WEST SUSSEX COUNTY COUNCIL CONSULTATION

TO:	<u>Arun District Council</u> <u>FAO:Ms Myer</u>
FROM:	WSCC - Highways Authority
DATE:	3 April 2020
LOCATION:	Sunny Mead Farm North End Road <u>Arundel</u> <u>BN18 0DL</u>
SUBJECT:	<u>Y/33/20/PL</u> Demolition of existing dwelling & outbuildings & erection of 7 No. dwellings comprising 3 No. 4 bed houses, 1 No. 3 bed house & 3 No 2 bed houses. This application is a Departure from the Development Plan.
DATE OF SITE VISIT:	27th March 2020
RECOMMENDATION:	No Objection
S106 CONTRIBUTION TOTAL:

- Proposed Site Plan (drawing no:P120 Rev P1)
- Design & Access Statement
- Visibility Splays & Swept Path Analysis (drawing no:2018-4297-001 Rev A)
- Vehicle Swept Path Analysis (drawing no: 2018-4297-002)

proposed site plan 1:200

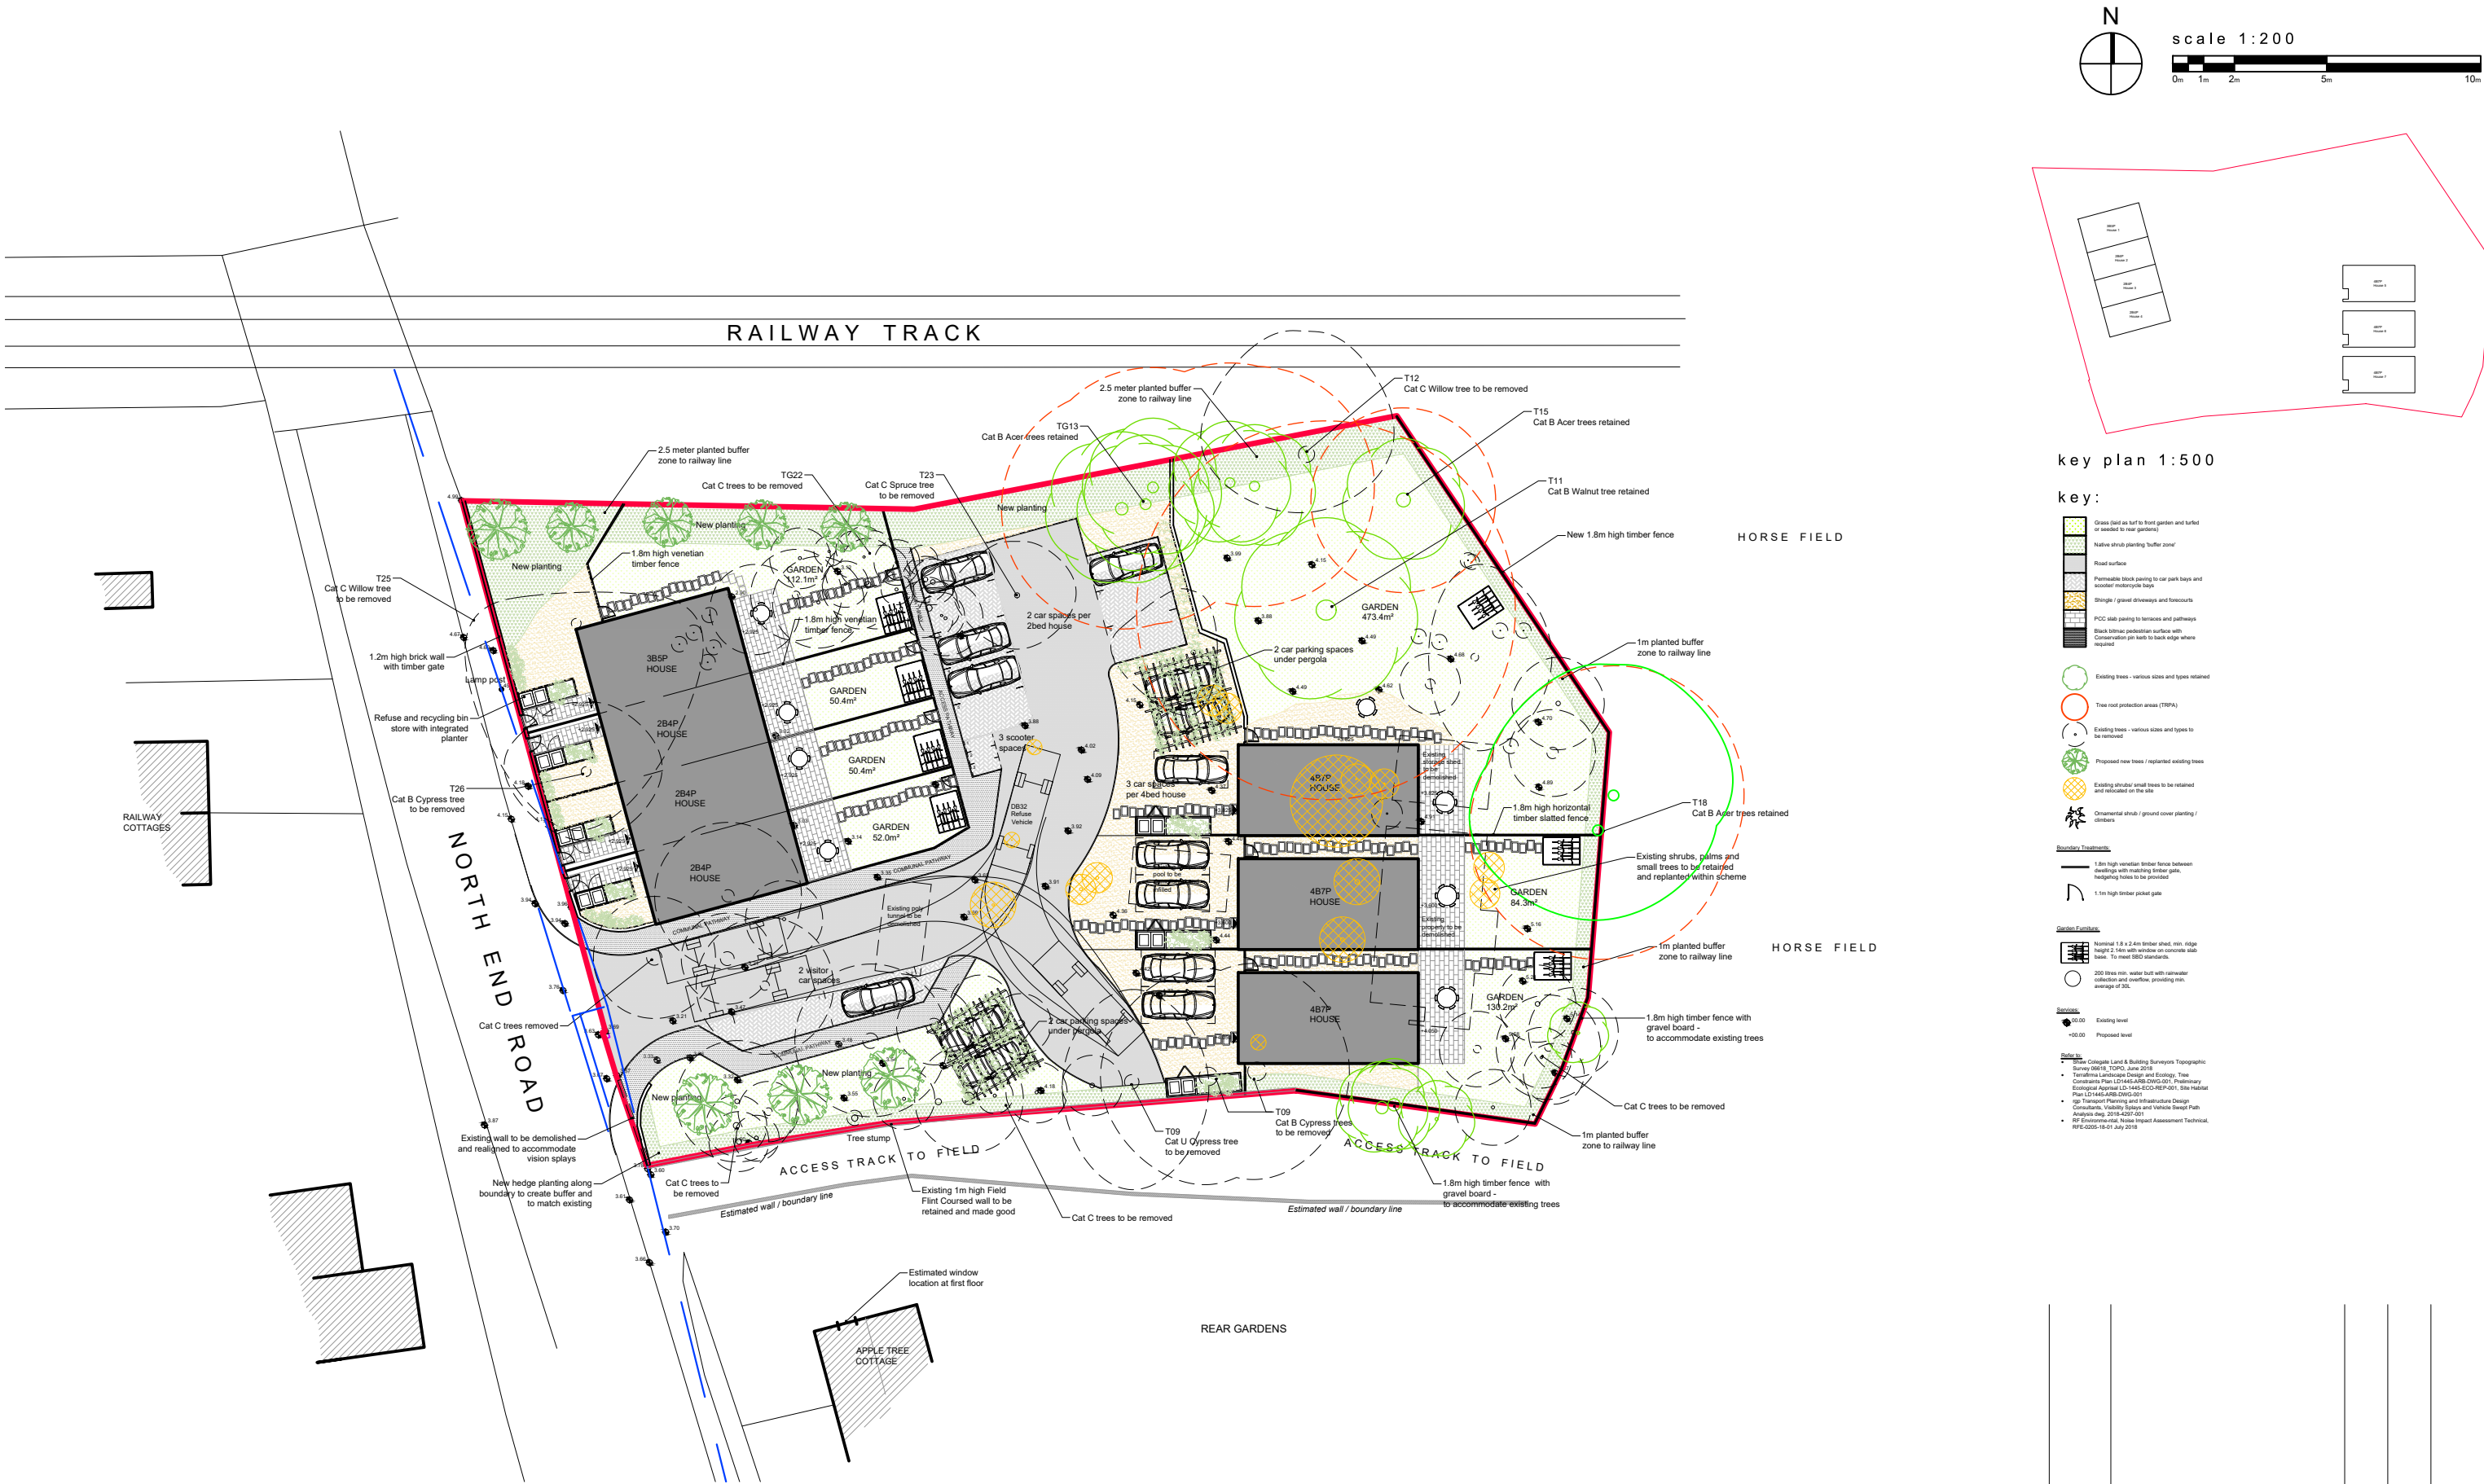
Vehicle swept path analysis has been demonstrated, showing that a service vehicle can enter and turn on site to leave the site in forward gear.

19 parking spaces are proposed. The LHA would raise no concern to this amount. It appears that there is adequate space for all spaces to be accessed.

Active charging points for electric vehicles should be provided at a minimum of 20% of all parking spaces with ducting provided at all remaining spaces where appropriate to provide 'passive' provision for these spaces to be upgraded in the future.

No part of the development shall be first occupied until the vehicle parking and turning spaces have been constructed in accordance with the approved plan. These spaces shall thereafter be retained for their designated use.
